Arborist Response

**Re: Royal Hall of Industries
Lot 3, (D.P.861843) and Lot 52 (D.P.1041134)
No. 1 Driver Avenue, MOORE PARK**

The following document provides a response to the request for additional information¹ regarding the application for the 'Adaptive reuse of the Royal Hall of Industries' (SSD-9726)¹. This document is based on the data provided in the Arboricultural Impact Assessment (referenced D3355, Date: May 2019) and related Addendum (referenced D3355A, Date: 18th October 2019). This response addresses Section 7 and 7.1 from the council document¹ and cites each Section and the response.

04
501 ROOF TERRACE - PLANTING CONDITION - TREE SECTION
SCALE 1:10

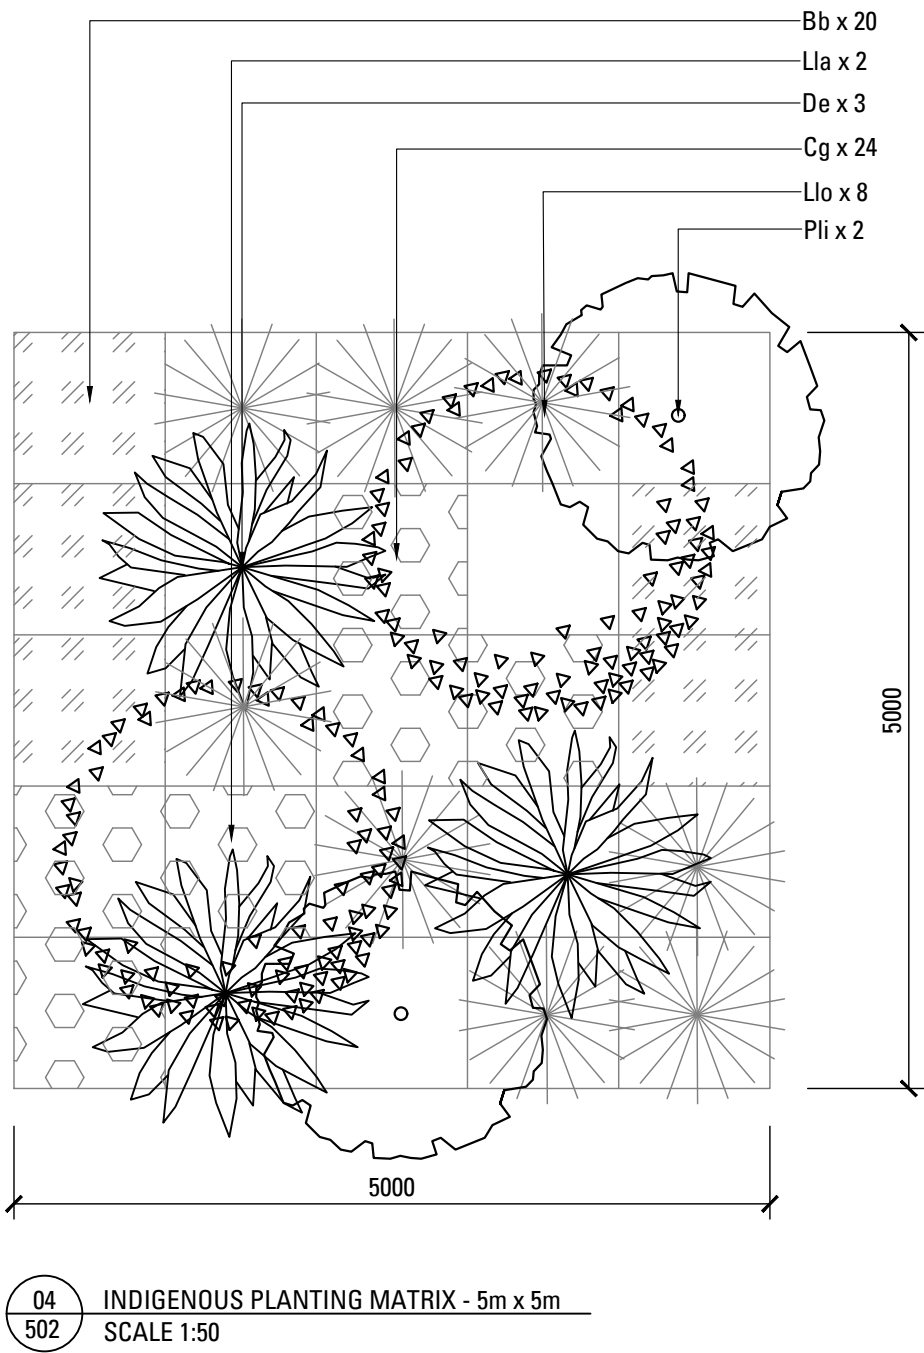
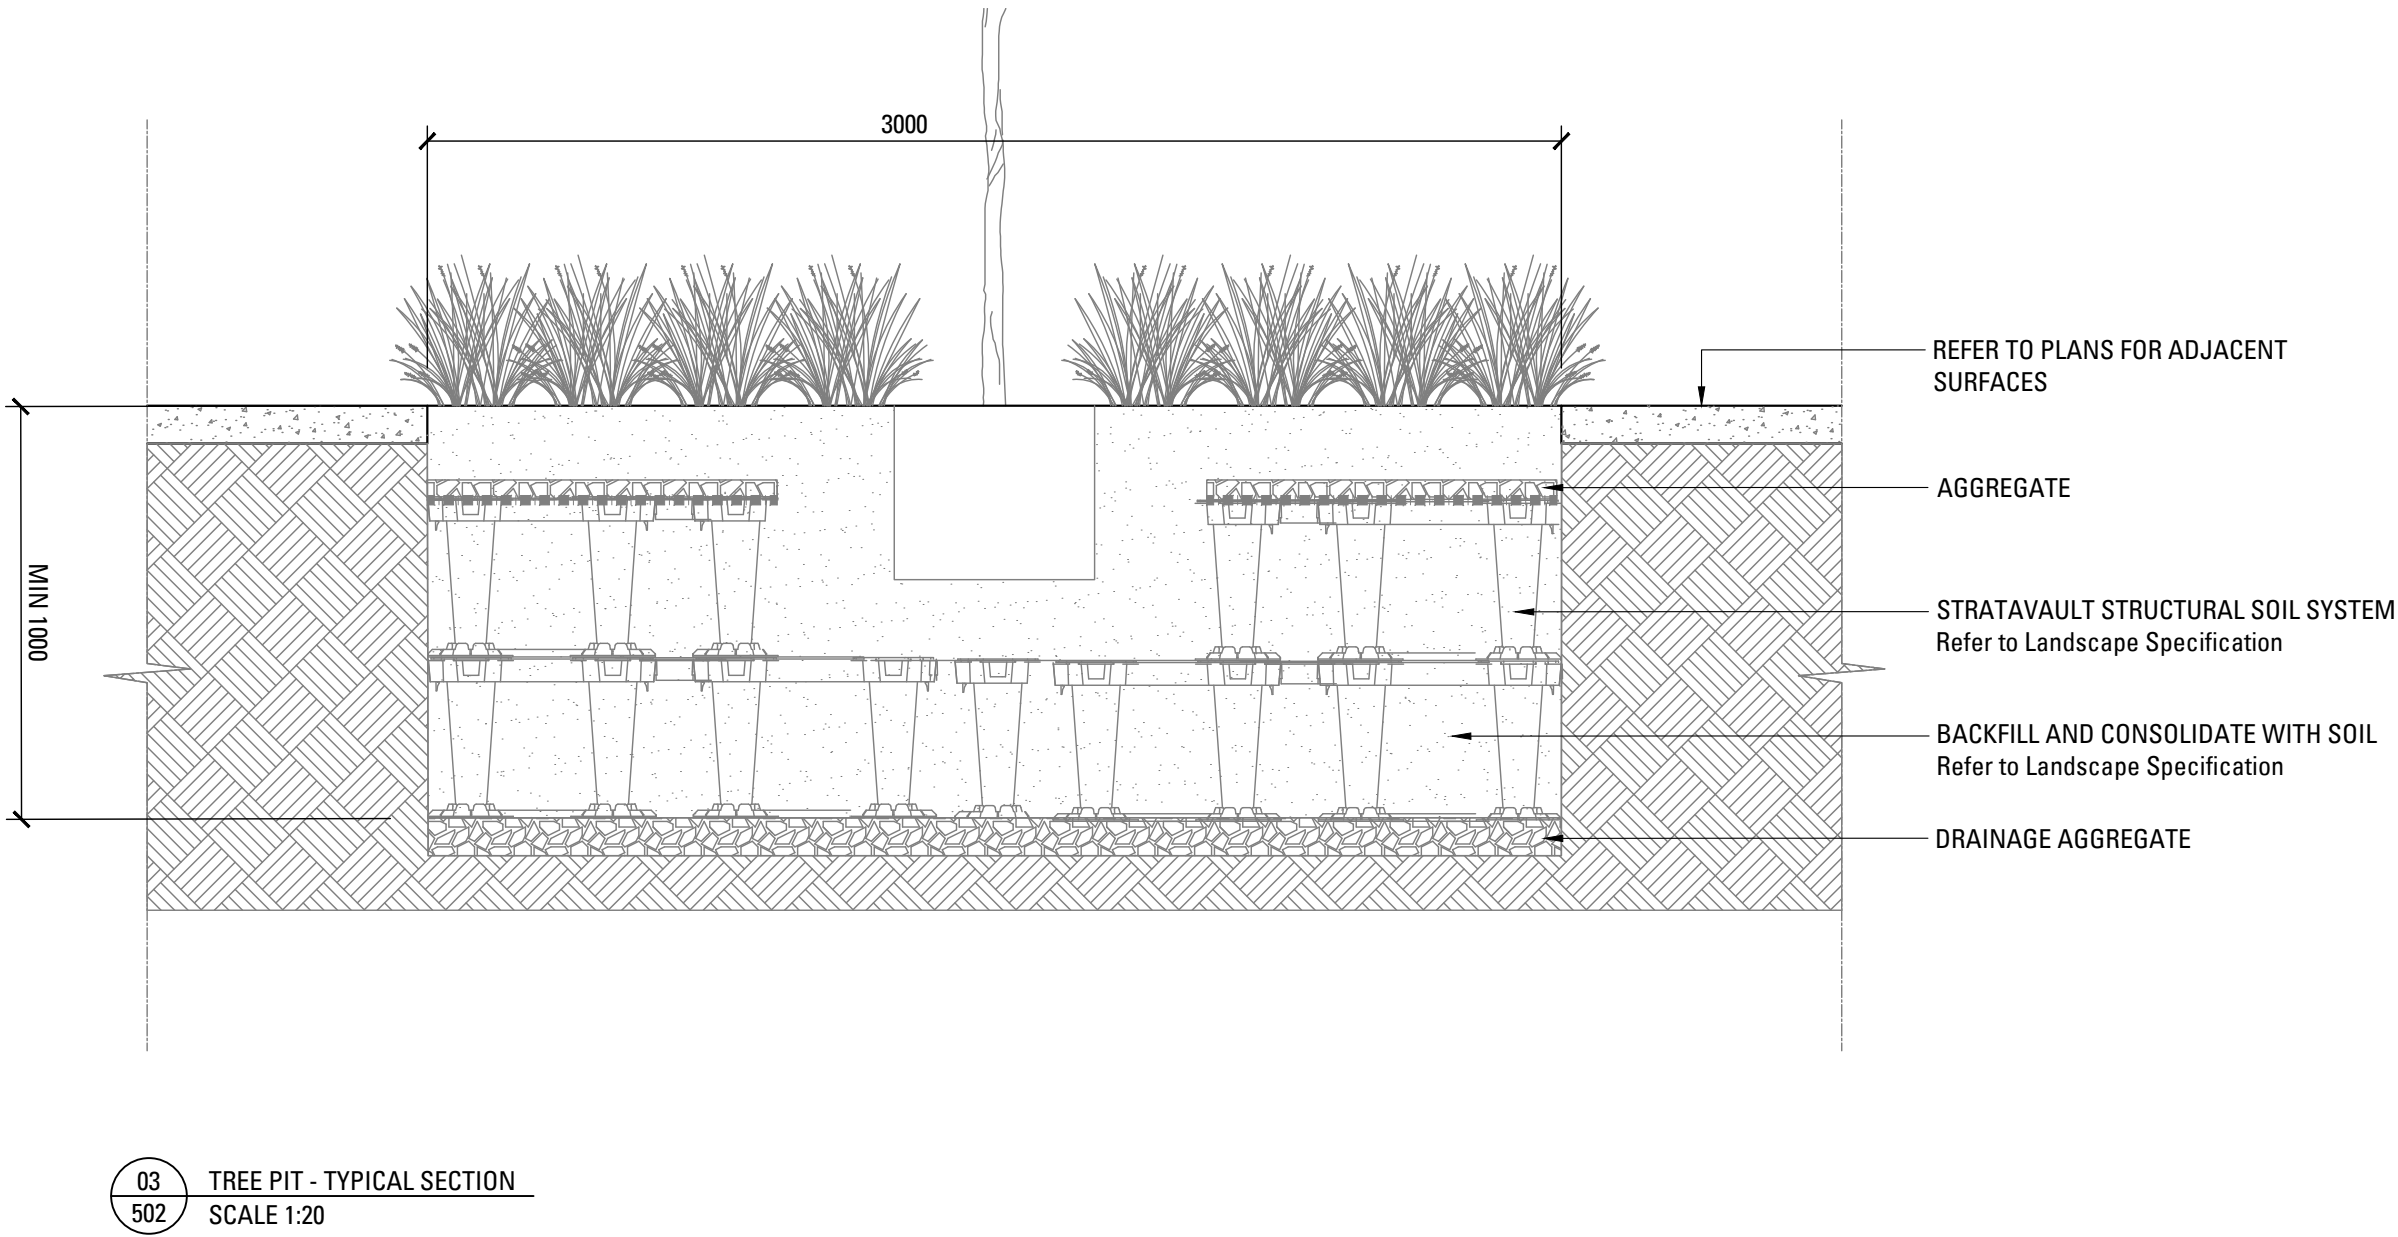
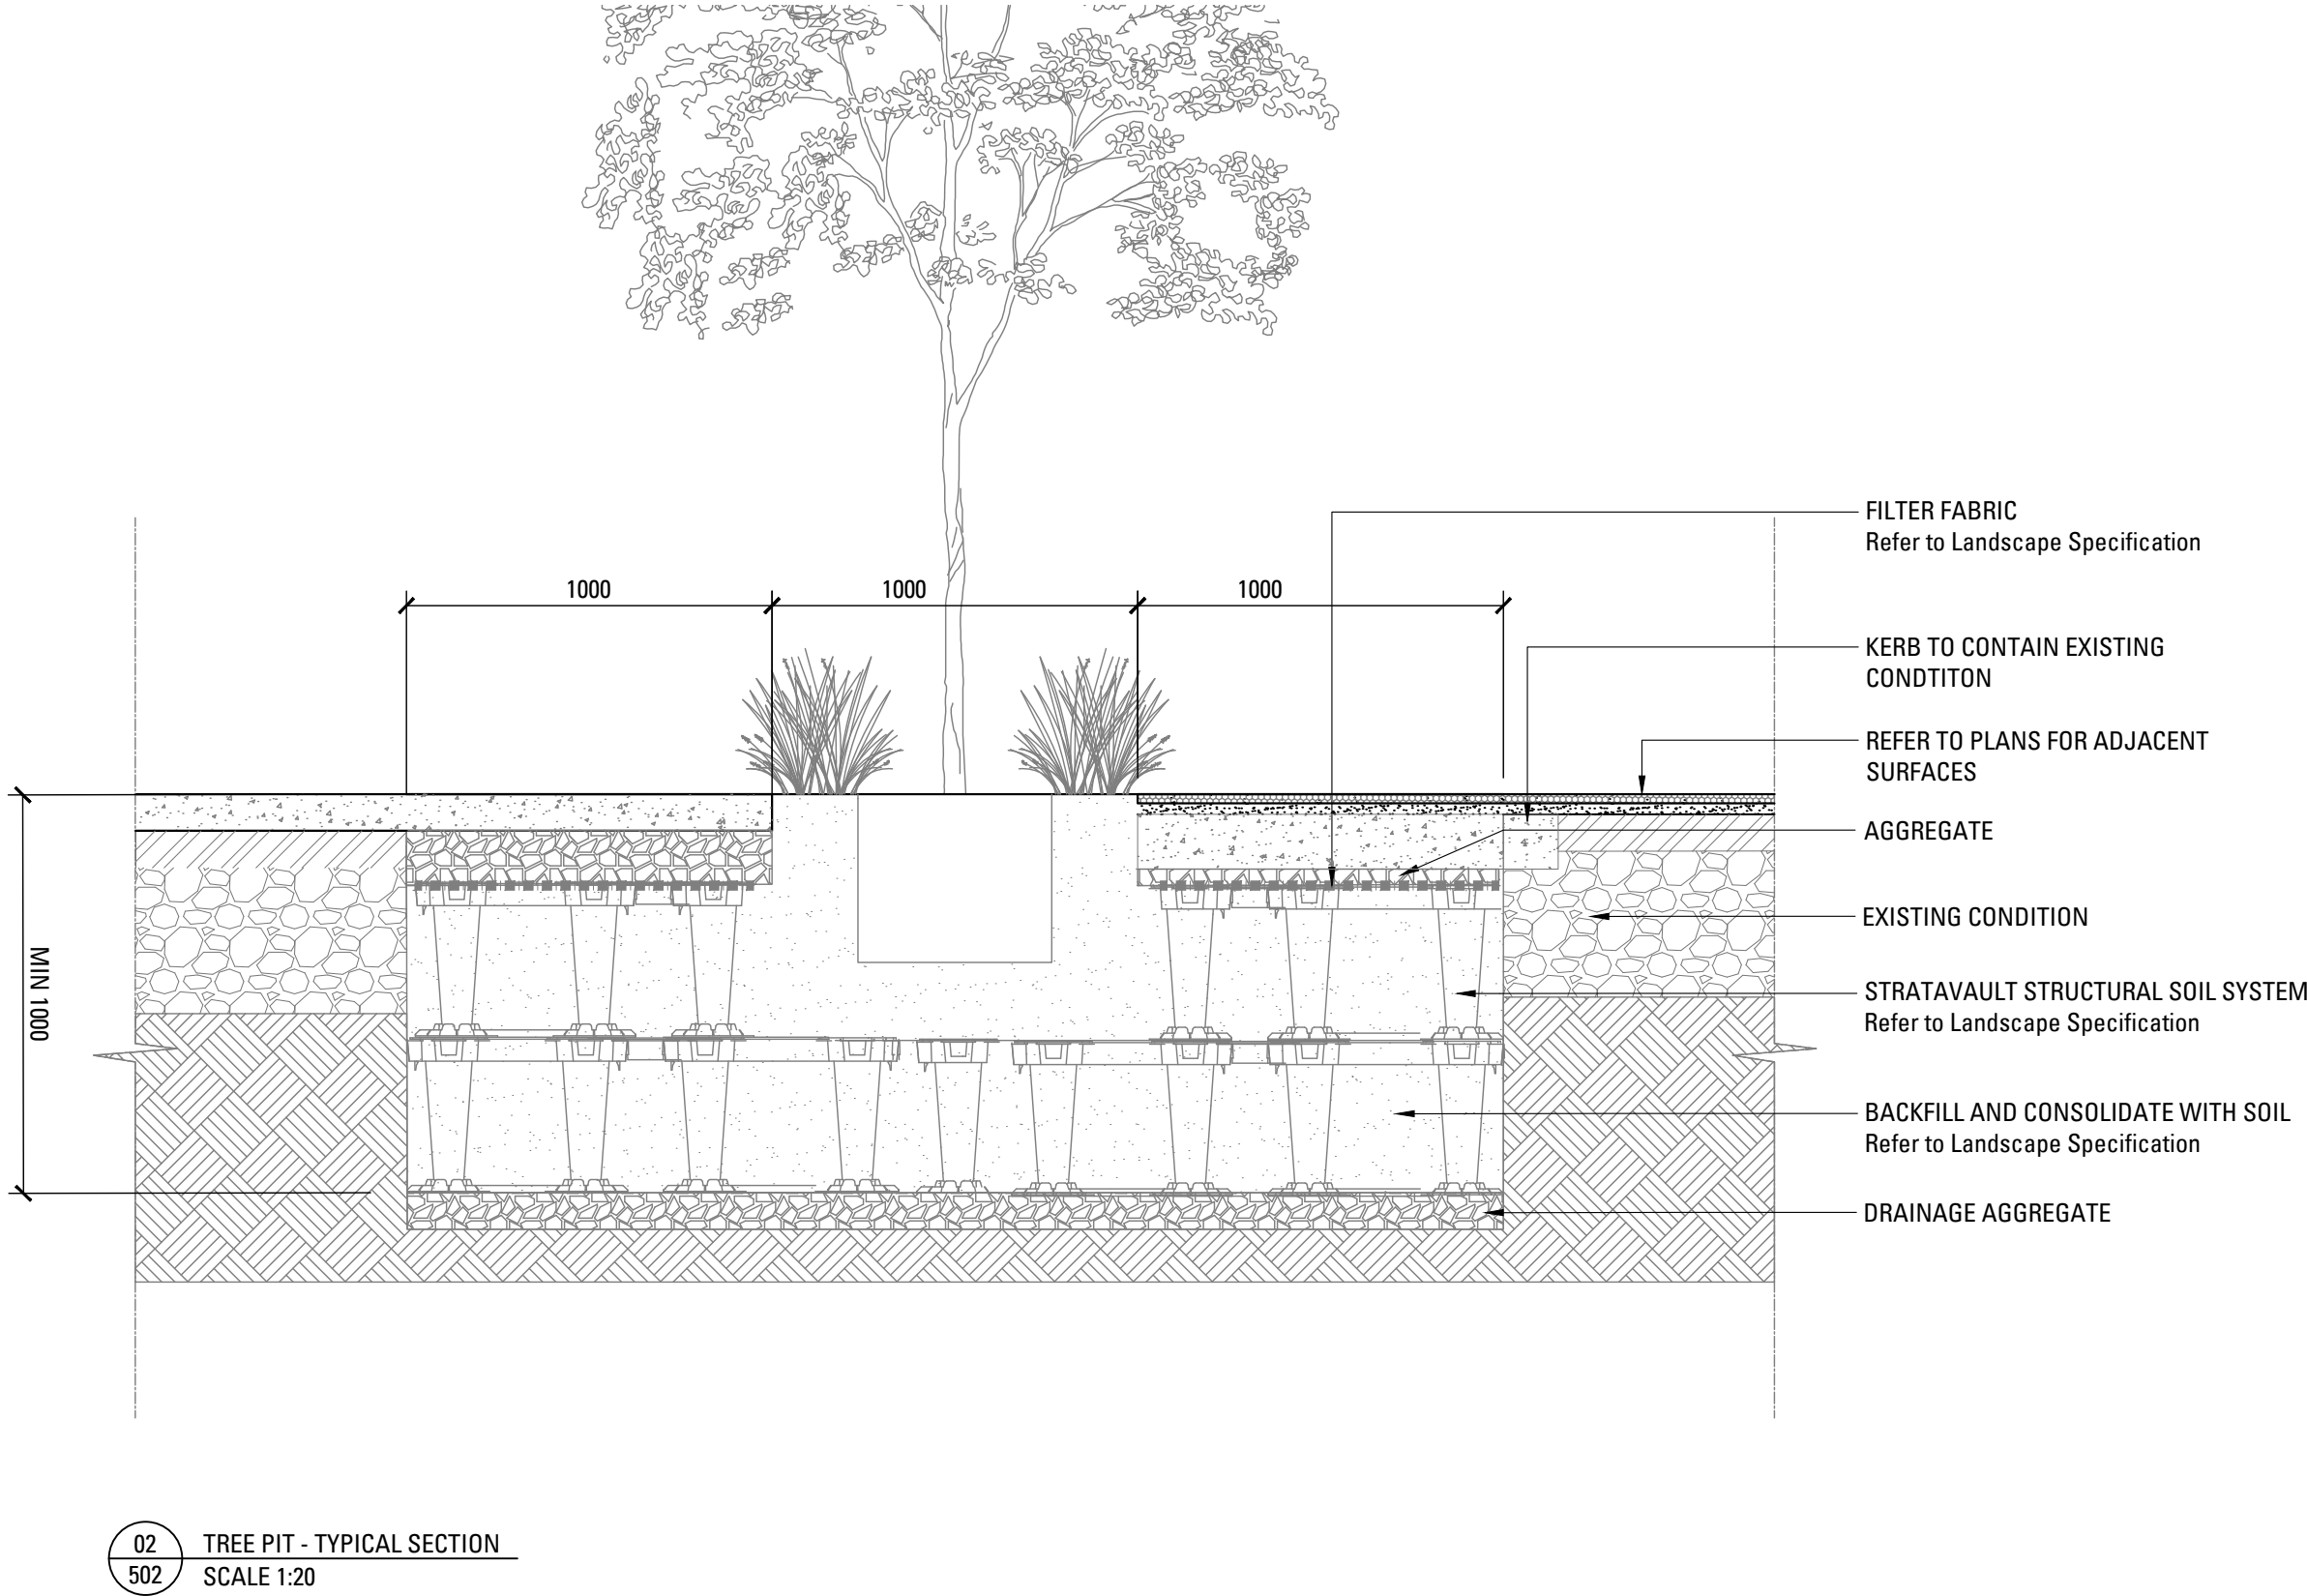
- e) *The Landscape Details indicate trees are planted into 'structural vaults'. The landscape plans do not clearly show where these vaults will be located*

This has been included in the Landscape drawing by *Arcadia*, January 2020, Issue G.
